Your ref: MP09_0099 MOD 4 and SSD 6962
Our ref: MC-09-1050

Modification to Concept Plan (MP09_0099 MOD 4) and State Significant Development (SSD6962) for 'Calibre' at 60 Wallgrove Road, Eastern Creek

ATTACHMENT A

Issues for consideration – SSD 6962 for ‘Calibre’ at 60 Wallgrove Road, Eastern Creek (former Quarantine Station)

Figure 11: Northern Elevation Proposed Screen Planting – Year 1 to Year 8 Screening Growth

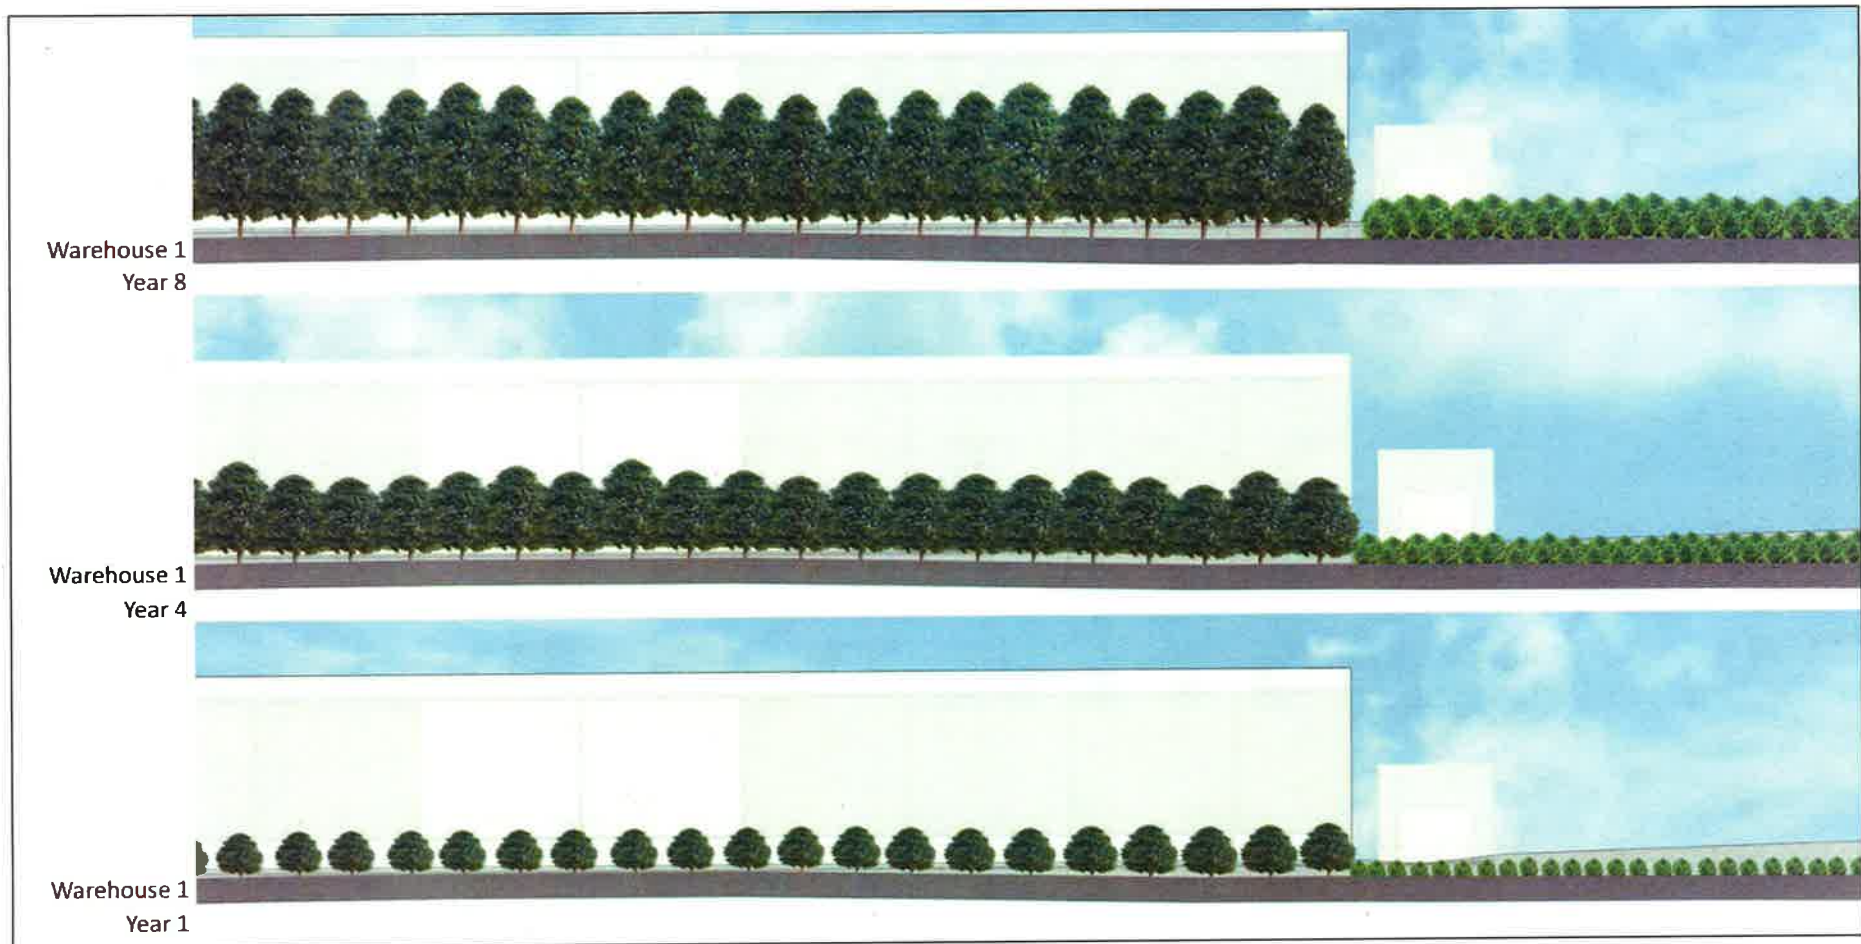
To address potential visual impacts, the applicant has indicated that tree planting and screening shrubs will be provided along the northern boundary. The width of the landscape setback along the northern boundary, however, has not been nominated. As such, it is unclear if sufficient area has been provided to achieve the level of screening proposed.

It is also unclear how the proposed landscaping along the northern boundary will be accessed and maintained. The submitted landscape plan (drawing no. L006 at Appendix C of the applicant's EIS) indicates that the narrow strip of landscaping will be provided between a retaining wall and the boundary fencing. The effectiveness of the tree planting is therefore questionable, especially given the significant change in levels between the proposed landscape strip and the finished floor level of the buildings. It is therefore recommended that the Department review the landscape arrangements along the northern boundary to ensure that adequate screening will be provided to eliminate any visual impact from the residential areas to the north and that the landscape area will be able to be appropriately maintained at all times.

- i. The width of the landscape setback along the northern boundary, including evidence to demonstrate that sufficient area has been provided to achieve the level of screening proposed.
- ii. Details of how the proposed landscaping along the northern boundary will be accessed and maintained. The submitted landscape plan (drawing no. L006 at Appendix C of the applicant's EIS) indicates that the narrow strip of landscaping will be provided between a retaining wall and the boundary fencing and therefore will be difficult to maintain.
- iii. Additional screen planting adjacent to the M4 road corridor and fronting Wallgrove Road. In particular, tall tree planting should be undertaken along the southern boundary addressing the M4 Motorway. The selected tree species should have a potential height of 15m and should be spaced at 10m centres.

Figure 19: Proposed Stormwater System

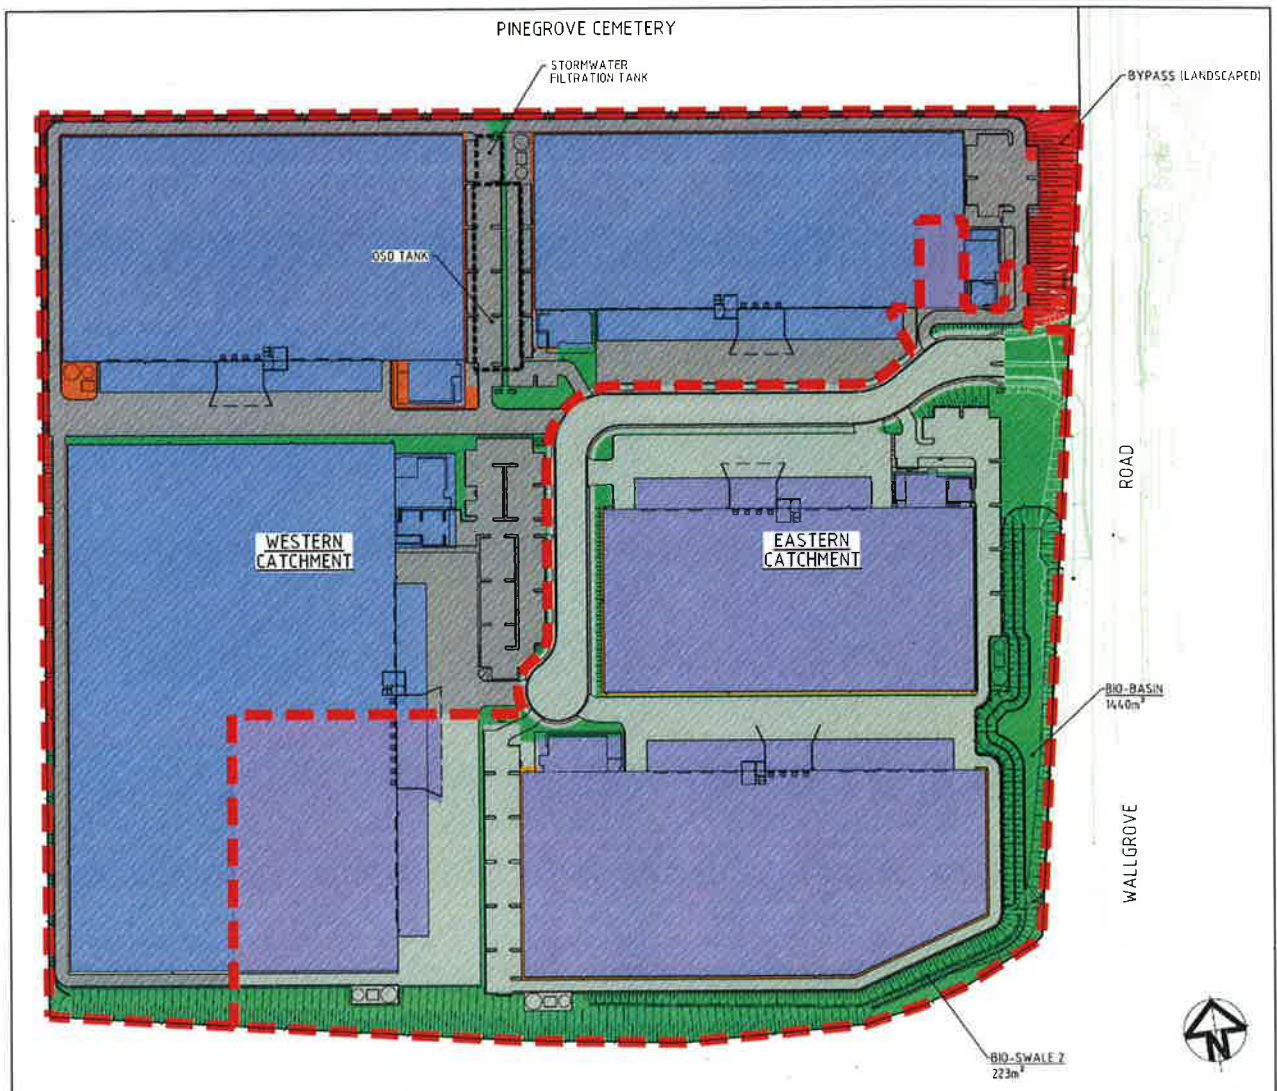
The review indicates that the applicant's drainage plans do not match the MUSIC model and that the waterway stability controls in Council's DCP have not been addressed. The targets under Part R of DCP 2006, however, can be achieved subject to the recommended drainage conditions provided at Attachment B of this letter. The drainage plans will need to be amended to meet the targets under Part R of DCP 2006.

2.7.1 Amended drainage plans from AT&L consultants (reference 12-108, revision B dated 28 May 2015) are to be provided to meet the requirements under Council's DCP Part R 2006 and Council's Engineering Guide for Development 2005. The amended plans must address the following:

- i. The minimum filter media area of 223 m² for the bioretention swale and 1445 m² for the bioretention basin are to be clear of pits and scour protection. Provide dimensions on the plan.

- ii. The eastern catchment does not remove hydrocarbons or oils as part of the treatment train and the bioretention basin needs to be protected from sediment loads that will reduce its effectiveness. Consequently a series of proprietary gross pollutant traps (GPTs) are required on the major inflows into the eastern basin. The GPTs must have oil baffles to retain floatable pollutants, target fine and coarse sediments and be designed for a minimum 6 month treatable flow rate (75% of 1 year ARI). Such GPTs are required downstream of pits A\20 (663 l/s), G\10 (317 l/s) and AQ\4 (118 l/s). The location of the GPTs is to allow for vehicle maintenance access nearby for cleaning the device using an eductor truck.

Figure 2: Stepped retaining wall construction

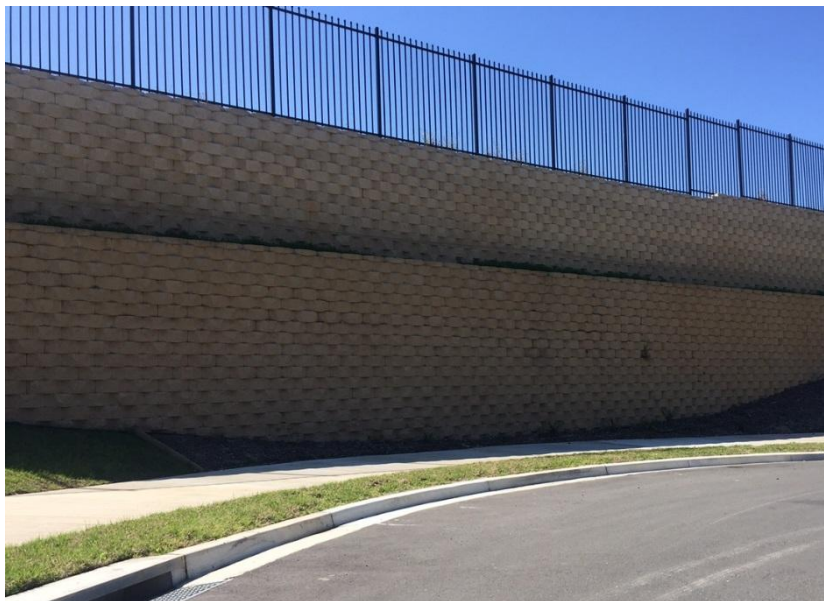
The applicant has indicated that retaining walls up to 4.5m in height will be provided as part of the development. Council requires the construction of masonry retaining walls (i.e. no timber walls). The retaining wall should also be in maximum 2 metres high sections and stepped with 1 metre wide minimum planting bays. A standard condition has been recommended to address these requirements, and the appearance and long term maintenance of the proposed retaining walls.

2.4.1 Details of any retaining walls including height and material to be constructed on site as part of the development are to be shown on the construction certificate plans. In this regard, Council requires the construction of masonry retaining walls (i.e. no timber walls). All proposed retaining walls shall be in maximum 2 metres high sections and stepped with 1 metre wide minimum planting bays to be landscaped.
